Appendix A - Response to Government and Independent Agency Submissions

Bays 5-15 Locomotive Workshop,
Australian Technology Park, Eveleigh
SSDA 8449

Submitted to Department of Planning &
Environment
On behalf of Mirvac Projects Pty Ltd

12 June 2018 17068

Roof Annex Signage Zones Elevation

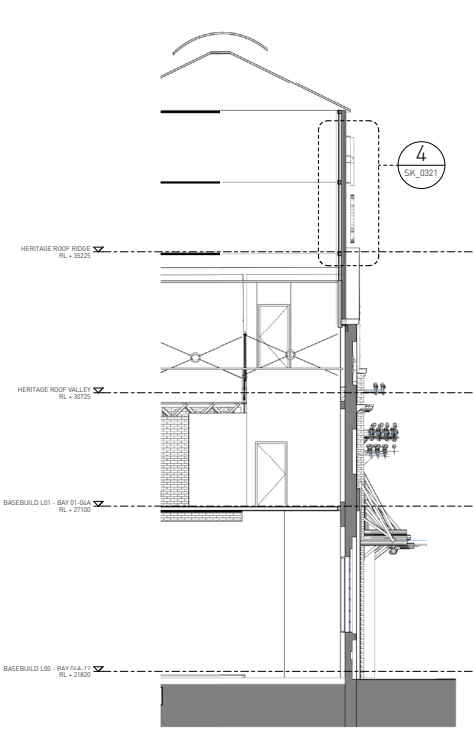
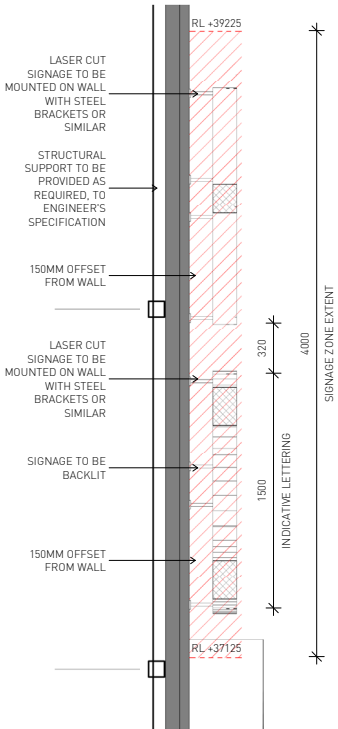
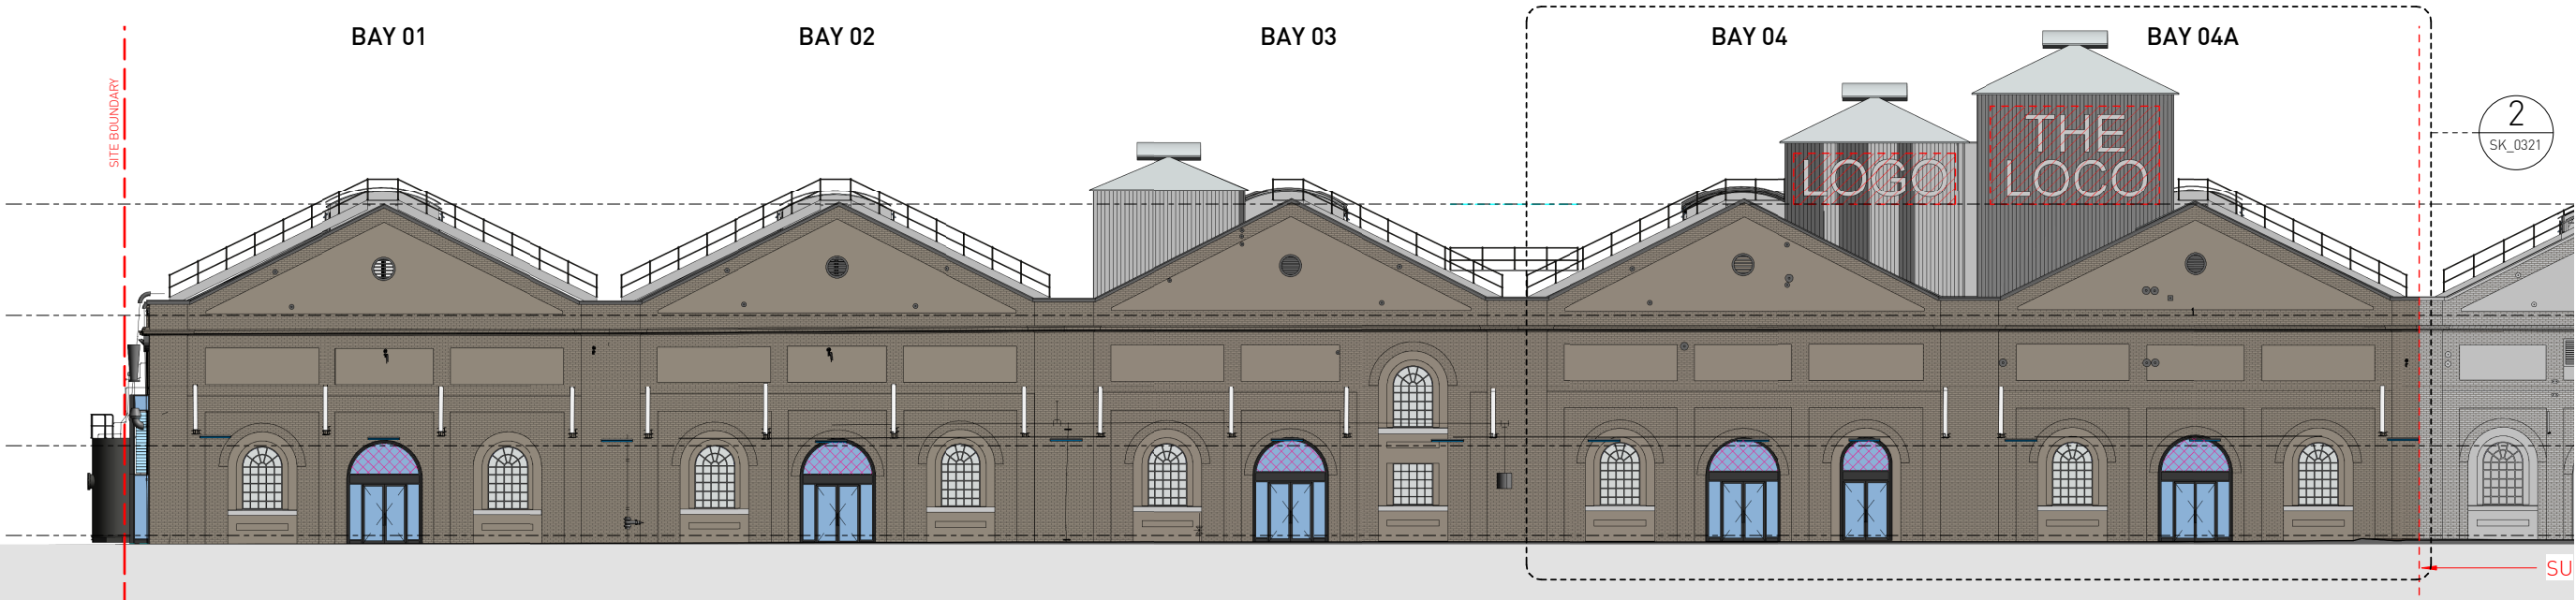
Incorporate the signage plan as part of the design framework and or heritage interpretation strategy for the building with further consideration of the visual dominance of the signage on the proposed service tower and signage on Annexes adjacent to Bay 4 and 4A.	✓	✓		Approval has been sought for signage zones only and separate applications will be submitted for the detailed signage design and content, materiality and illumination. As outlined within the Heritage Response report (Section 2.16), it is inappropriate for the signage plan to be incorporated within the heritage interpretation strategy. However, the detailed design will be sympathetic to the design and heritage significance of the building.
Confirm commitments to heritage interpretation and conservation works (e.g. Scope of works, timing of delivery, funding, consultation, on-going curation of exhibits, etc).	✓	✓	Section 2.2 & Section 2.3	The Heritage Response Report (Appendix D) provides a list of documentation that has been commissioned by Mirvac that demonstrates their commitment to heritage interpretation and ongoing active management to date. In addition, a suggested condition of consent is included in Appendix F .

Protective Wall Type - Plan Detail

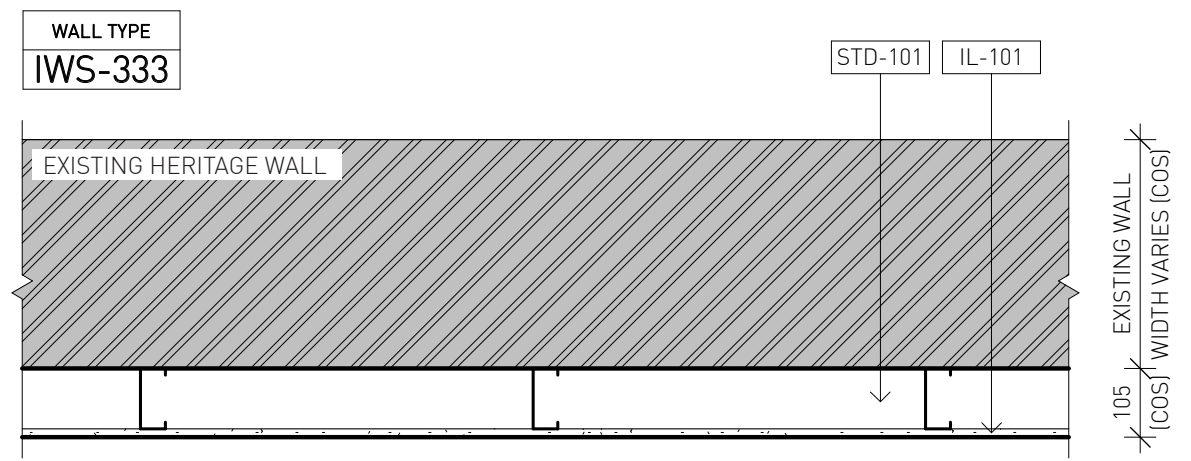
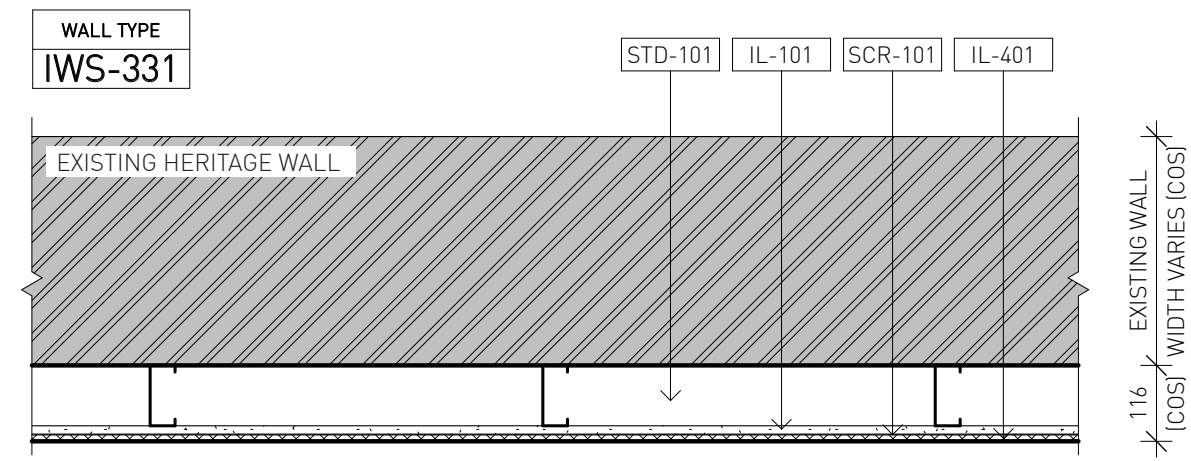
Treatments for back of house and storage areas. This information must have regard to	✓	✓		Details of the proposed protective wall treatments are included in the Response to Submissions Package, prepared by Sissons at Appendix H .

1 INTERTENANCY WALL PLAN
1:100

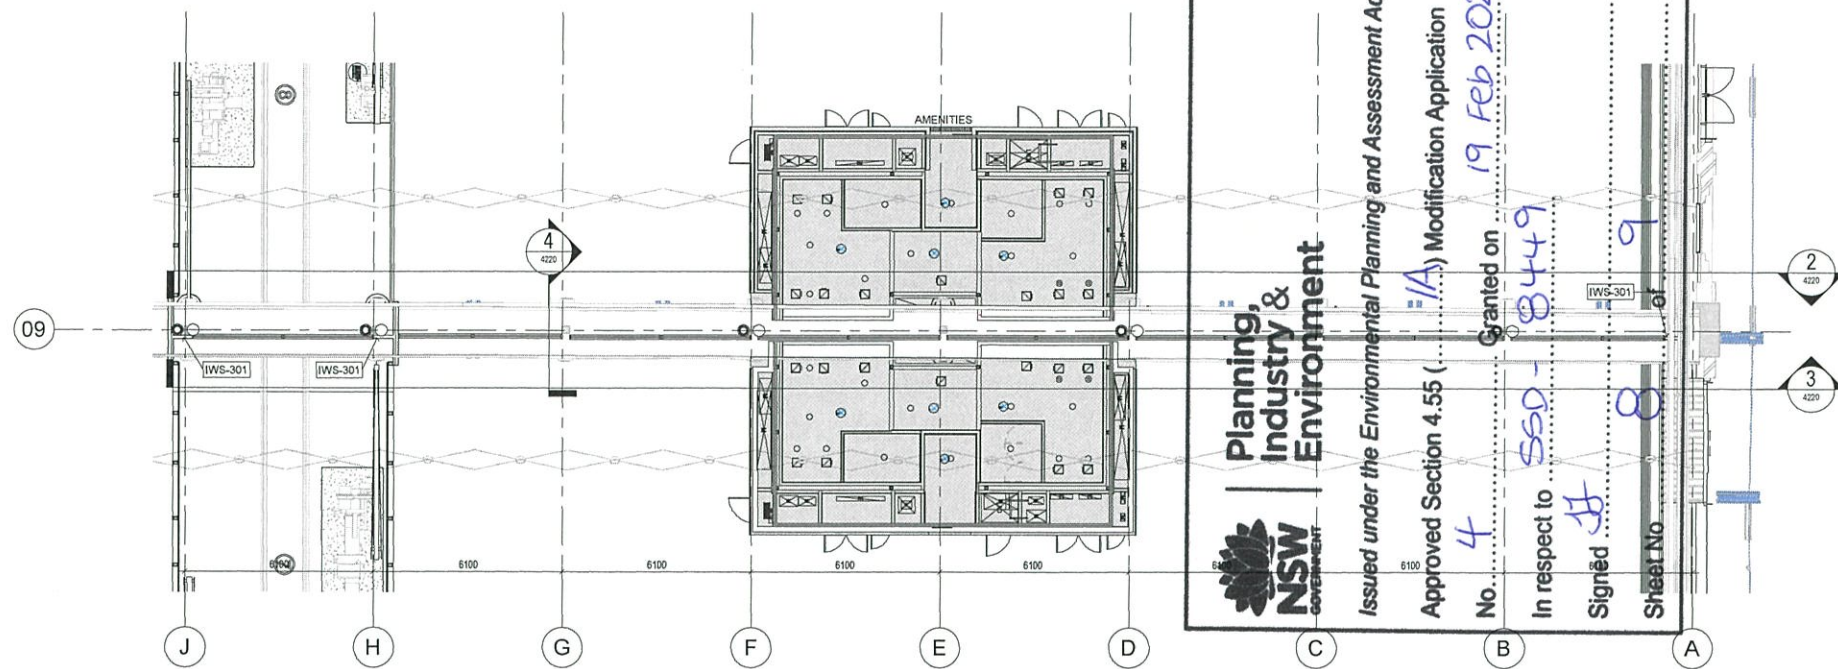
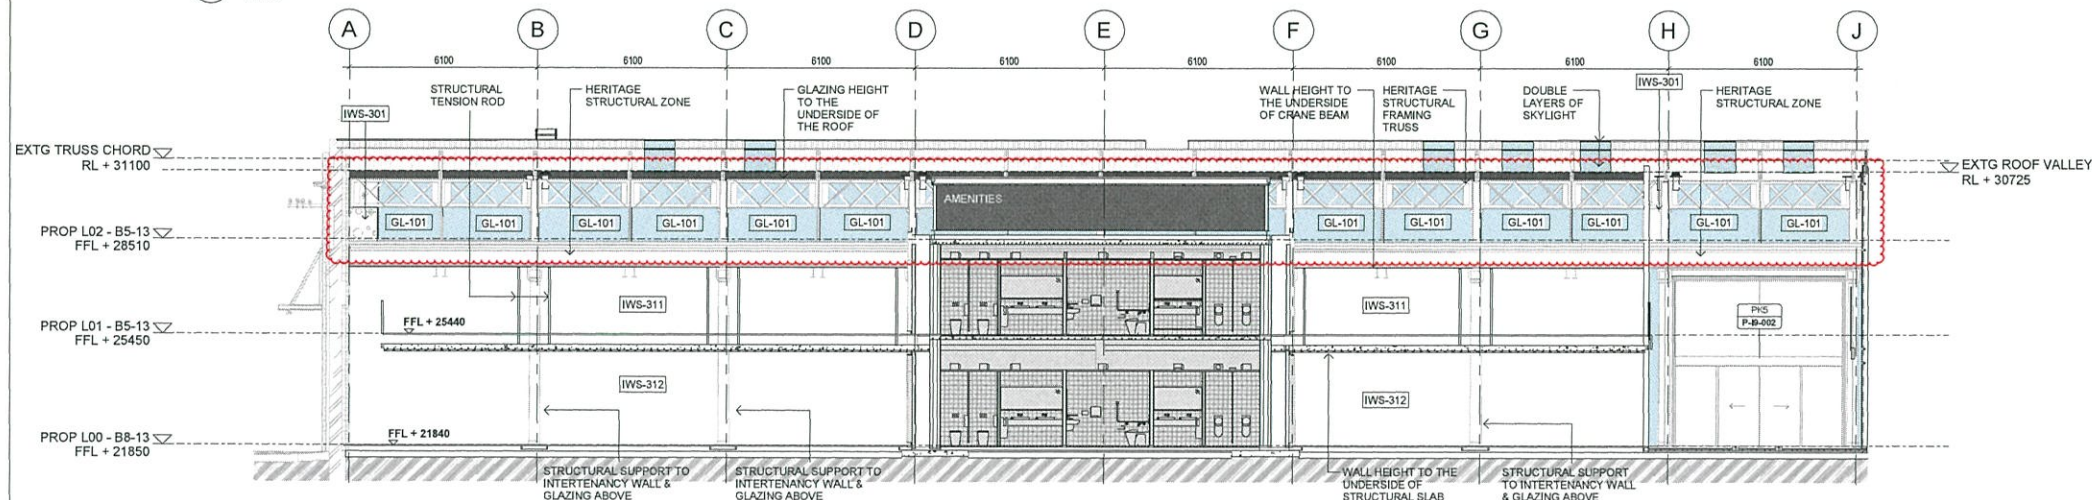
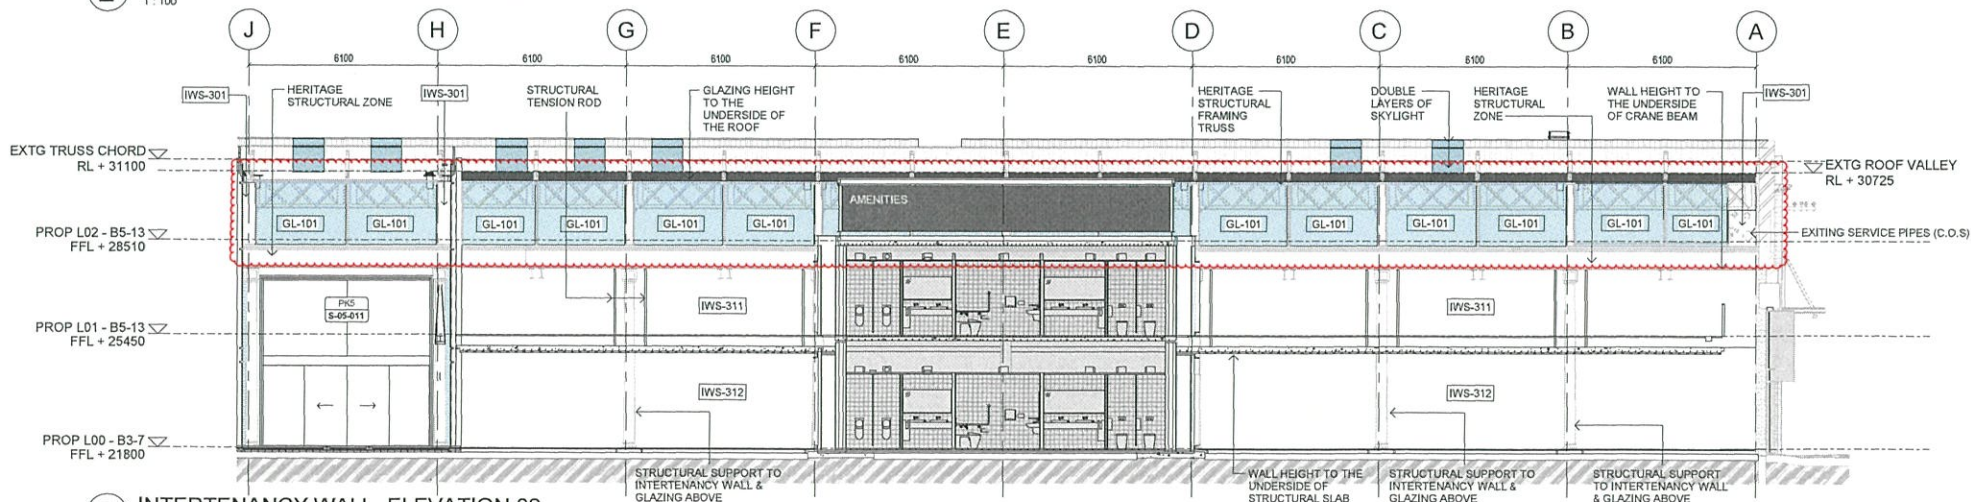
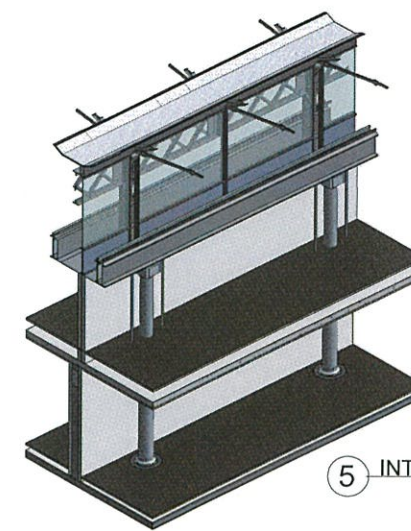
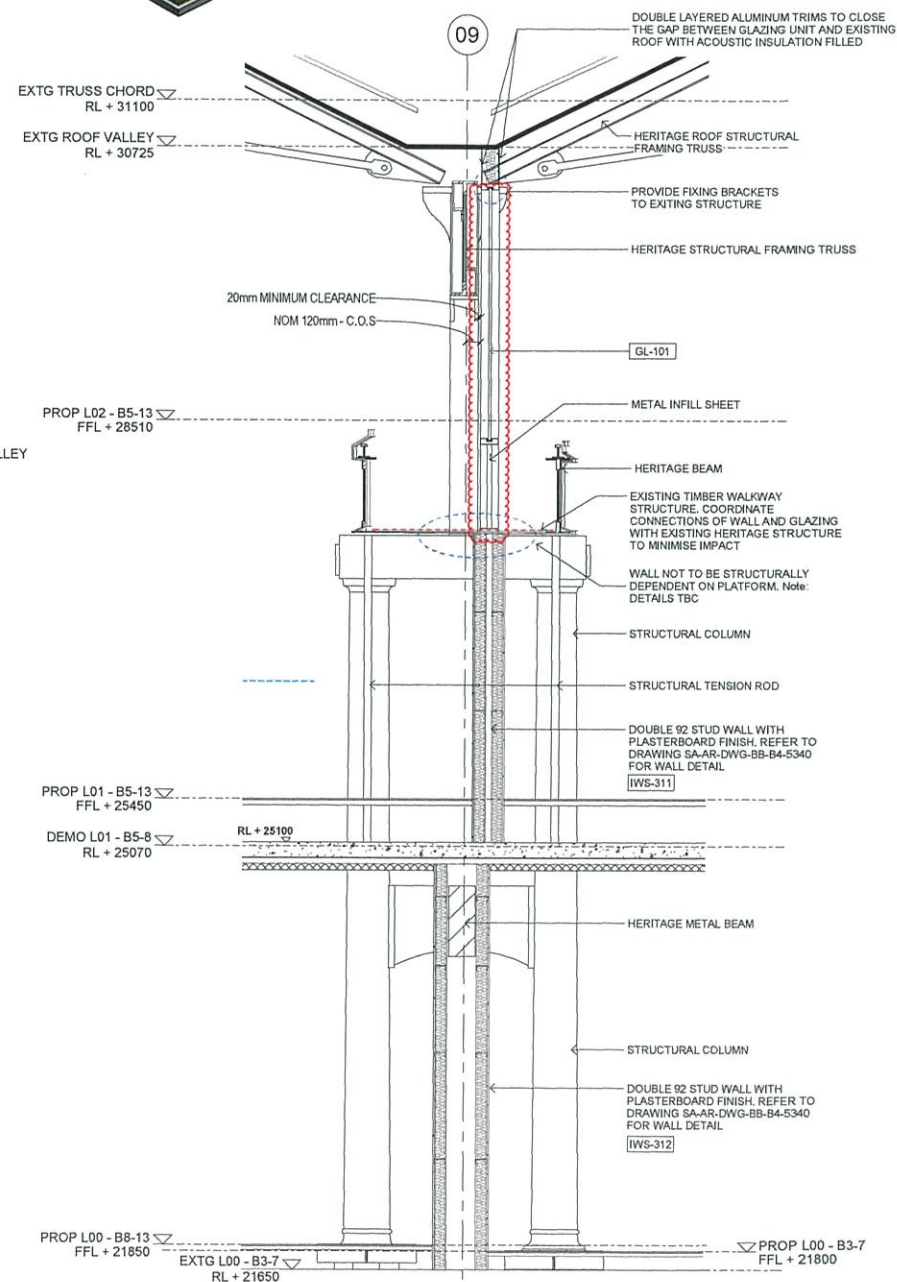
Consideration should be given to utilising alternative design solutions to the proposed intertenancy walls, such as fire curtains or concealed sliding doors. If this is not possible, a reduction in framing is recommended to make these intertenancy walls as transparent as possible and to retain the important east-west access view line to enable the large volume of the space to be understood.	✓	✓	Section 2.10	
Storage areas must be identified within internal spaces including for functions, retail and interpretation to ensure internal spaces are uncluttered and to limit the impact on the visitor experience. Detailed designs must be provided to the Heritage Council prior to the approval of this project.	✓	✓		A Heritage Store is proposed at Ground Floor level in Bay 15. The details design of other areas will be either provided prior to the relevant Construction Certificate or within a separate development application.
